Our Ref: AW/20/19/HH

Town & Country Planning Act 1990 (as amended)
Town & country Planning (Development Management Procedure) (England) Order 2015
Application for Planning Permission for Works or Extension to a Dwelling

Development TO ERECT A WHITE PVCu FRAMED CONSERVATORY TO THE SIDE OF THE PROPERTY

Location 22 Robins Drive Aldwick

Scale: 1:1250

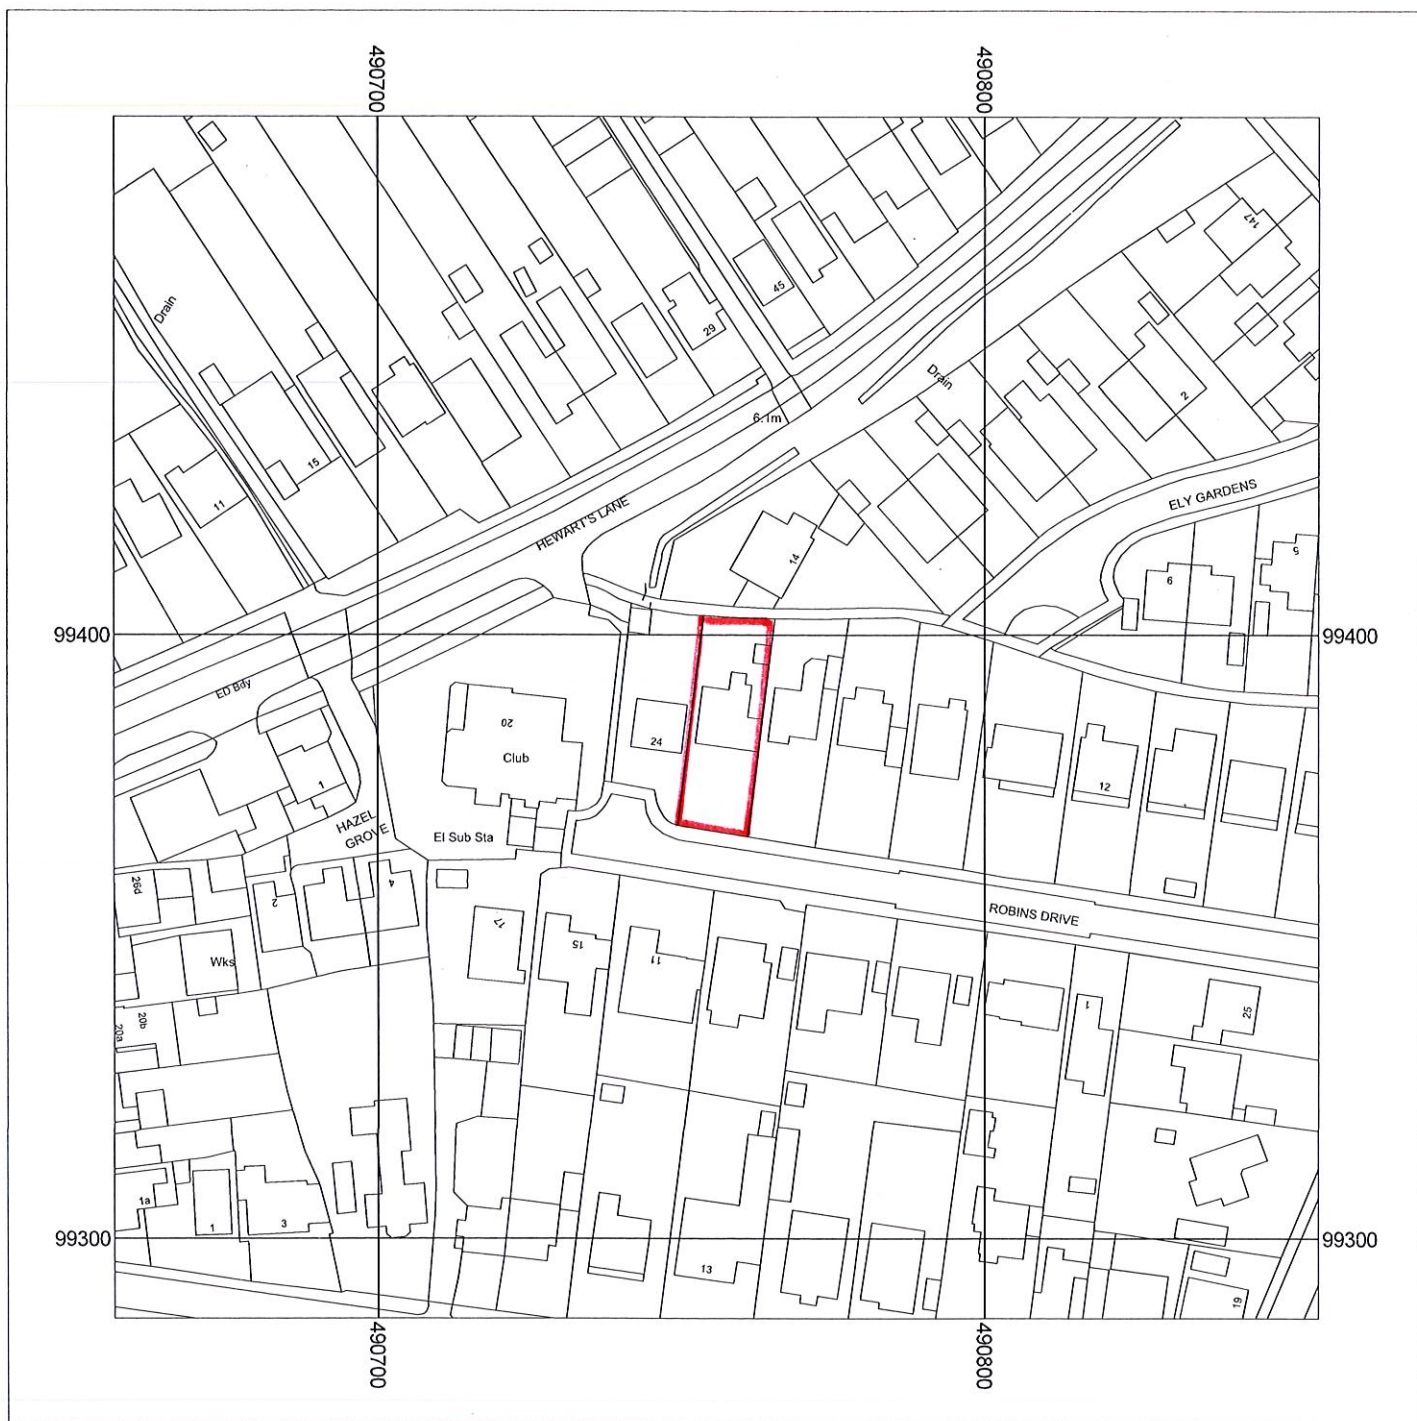
Shape of extension: The shape and position of the property does not match between the block plan and all other floor plans. Please amend
